PLOT PLAN DRAWING

PROJECT NAME: 5930 Pacina Ct.
 SUBMITTAL DATE: 5/10/2018
 SUBMITTED BY: A Martin
 SUBMITTAL REVIEWED BY: _____

SITE PLAN DRAWING

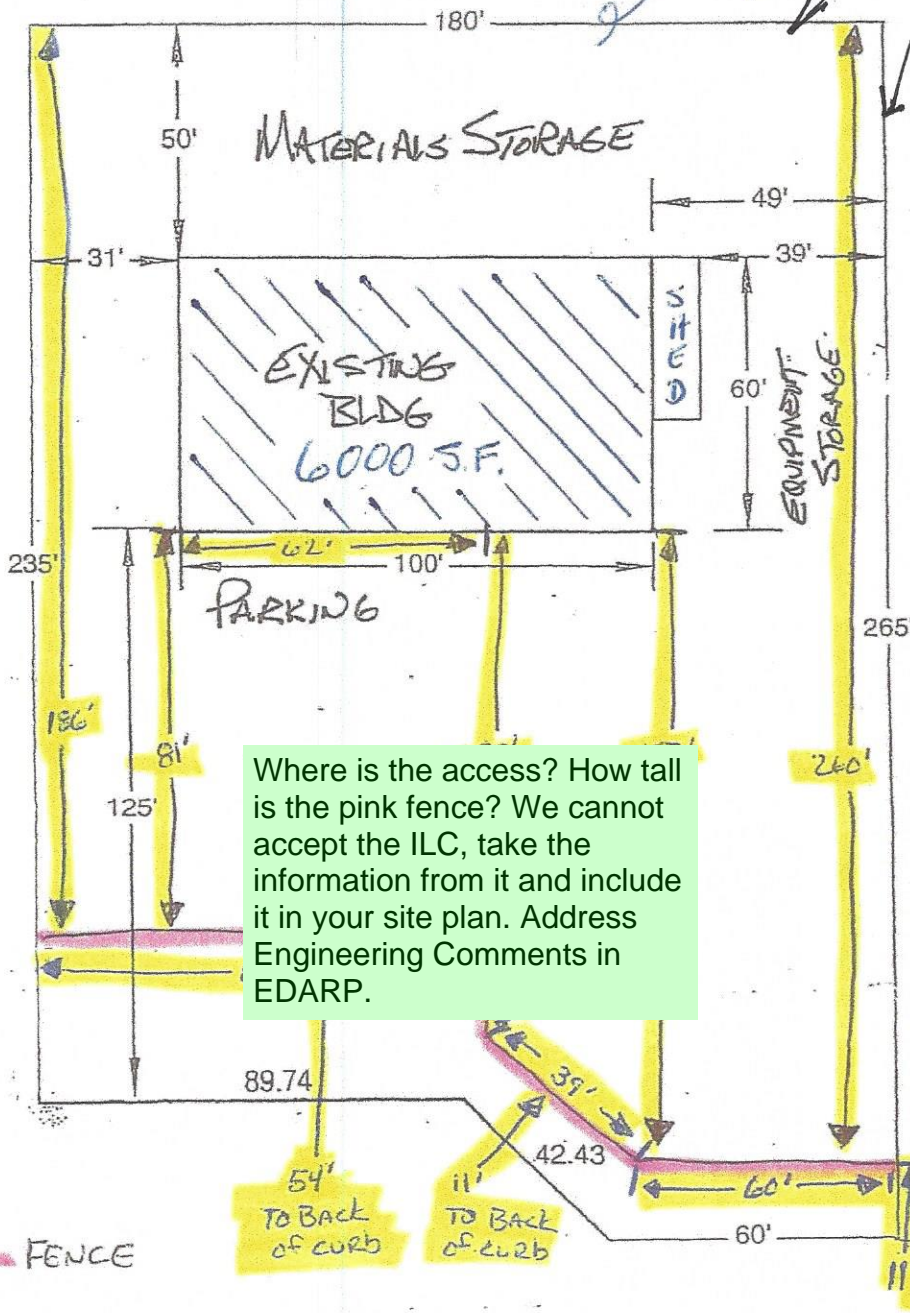
Needs Screening

Show easements.
 Outdoor storage must be screened 100% either by 6' fence, wall, or landscaping.
 Outdoor storage not to exceed height of screening, if it does it is to be placed in the rear 1/3 of the property. (Land Development Code 5.2.38 - Outside Storage)

How tall is the fence?
